April 4, 2022

Re: White Barn Dental
PreApp 22014

RE: White Barn Dental, File# PREA22-014
New Dental Office
8833 Soper Hill Rd & Parcel # 00590700031800

TITANIUM OFFICE, LLC
DENTAL OFFICE - WHITE BARN
PRELIMINARY SITE PLAN

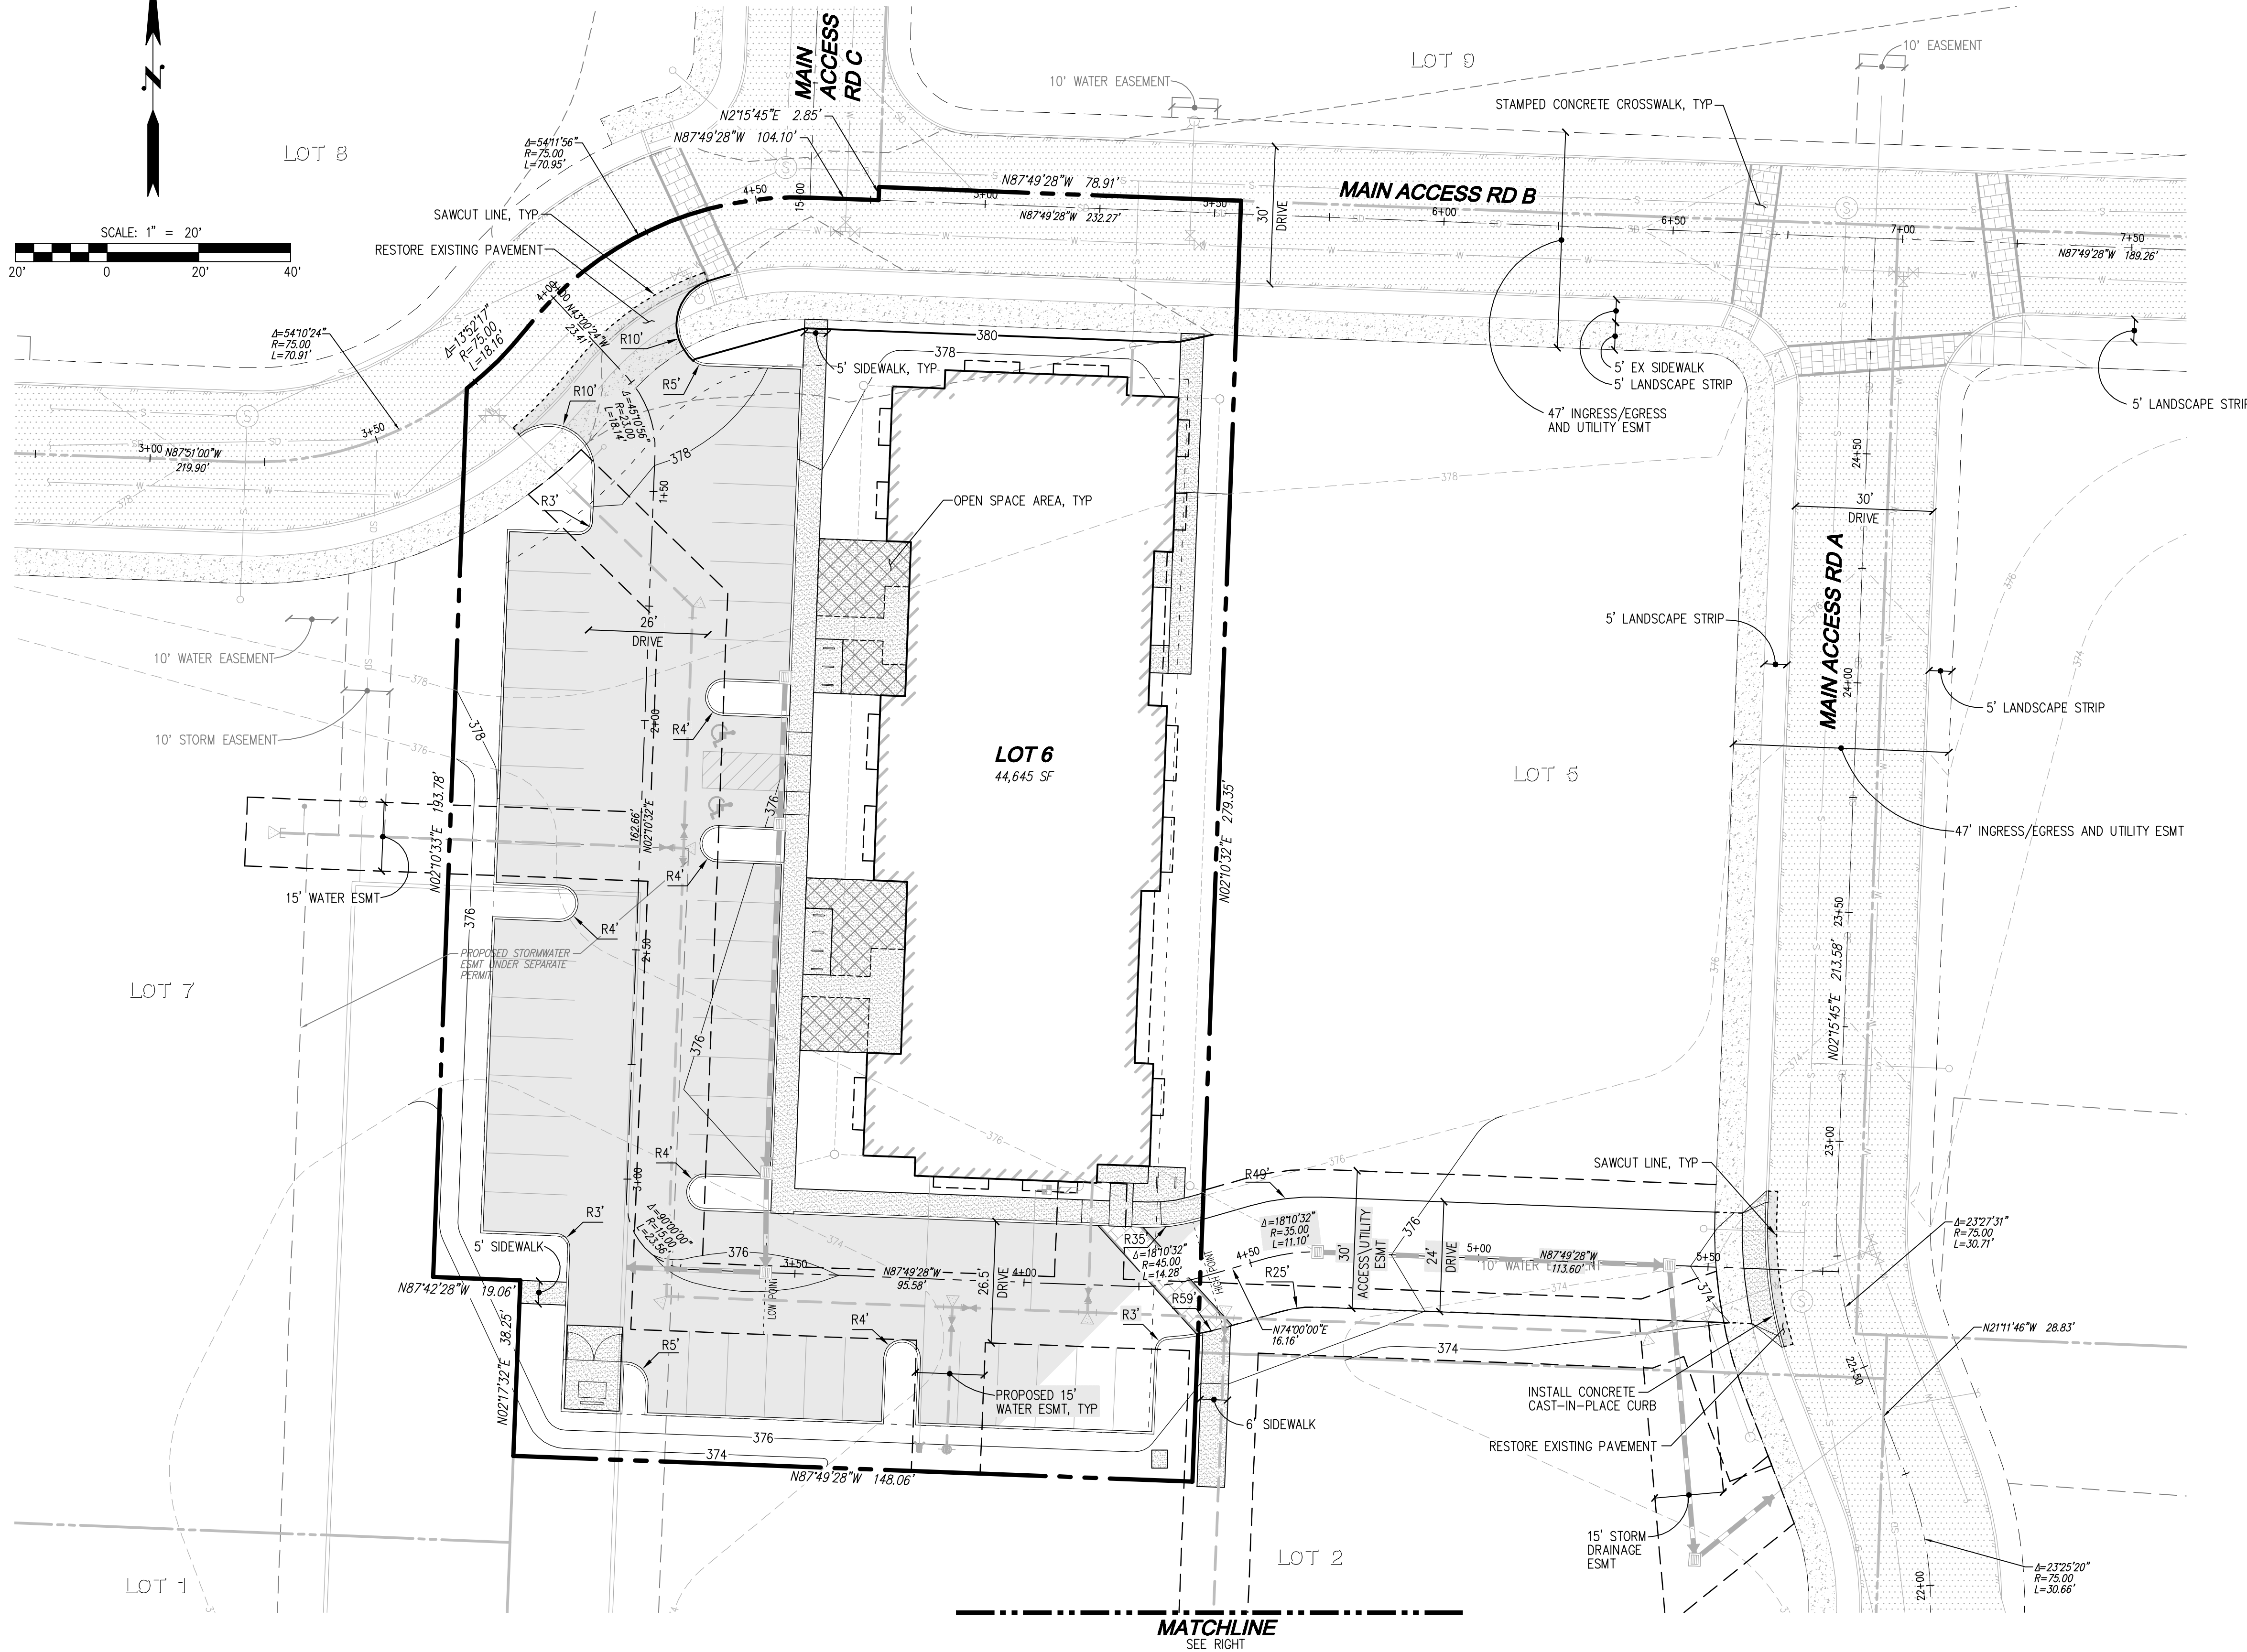
- c. A 10' L3 landscape buffer shall be installed between Drive B and the proposed parking stalls. This affects stalls 1 & 50.
 - d. Street trees shall meet the most recent ANSI standards for a minimum of 1 ½ – 2" caliper at the time of planting and shall be spaced to provide a continuous canopy coverage within 10-years of planting. Root barriers shall be provided for street trees.

- g. 10% of the required parking areas shall be landscaped with L4 landscaping, provided that:
 - . No parking stall shall be located more than 45' from a landscaped island (every 10 stalls). This affects the parking stalls proposed on the south side of the lot;

- . All landscaping must be located between parking stalls, at the end of parking columns, or between stalls and the property line;
 - . All individual planting areas within parking lots shall be planted with at least one tree, be a minimum of 5' in width and 120 SF in size, and in addition to the required trees, shall be planted with a living groundcover. This affects the landscape island adjacent to the dumpster and the landscape island located near the southwest corner of the proposed building;

TITANIUM OFFICE, LLC
DENTAL OFFICE - WHITE BARN
 PRELIMINARY ROAD AND UTILITY PLAN

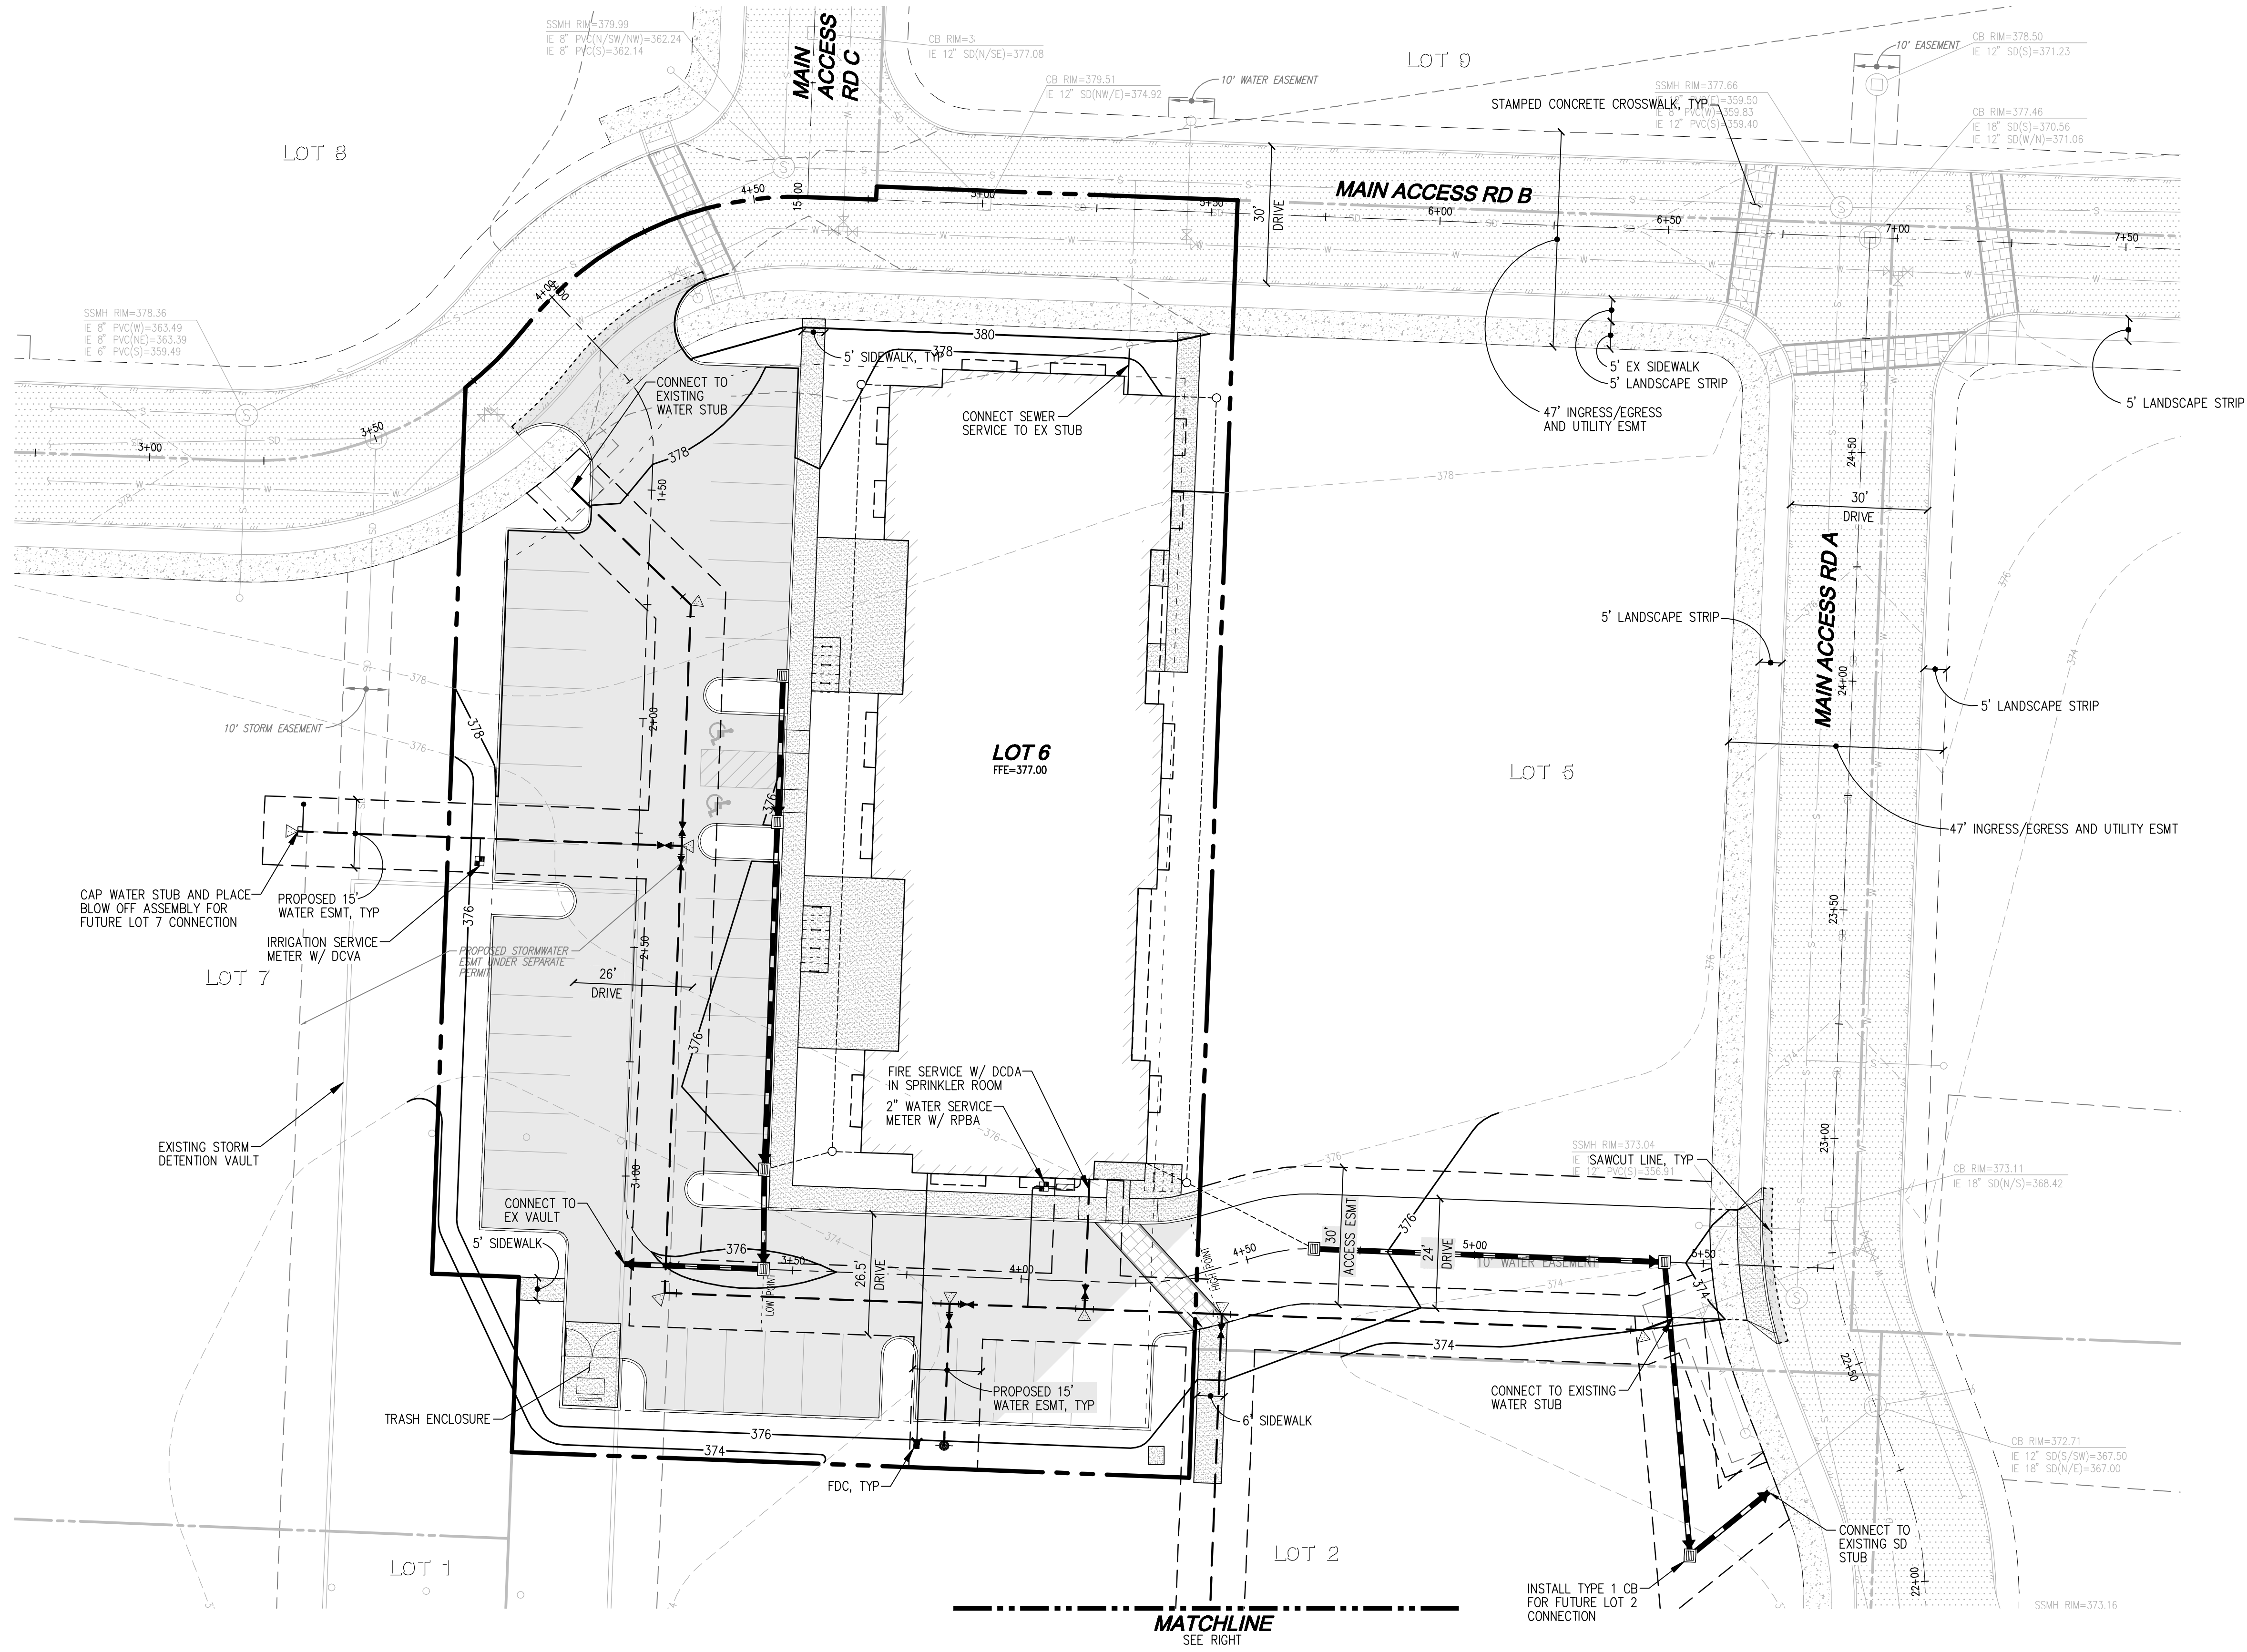
1. Water and corresponding details not shown, will comment when provided;
2. Install hydrant behind sidewalk and not in planter strip.
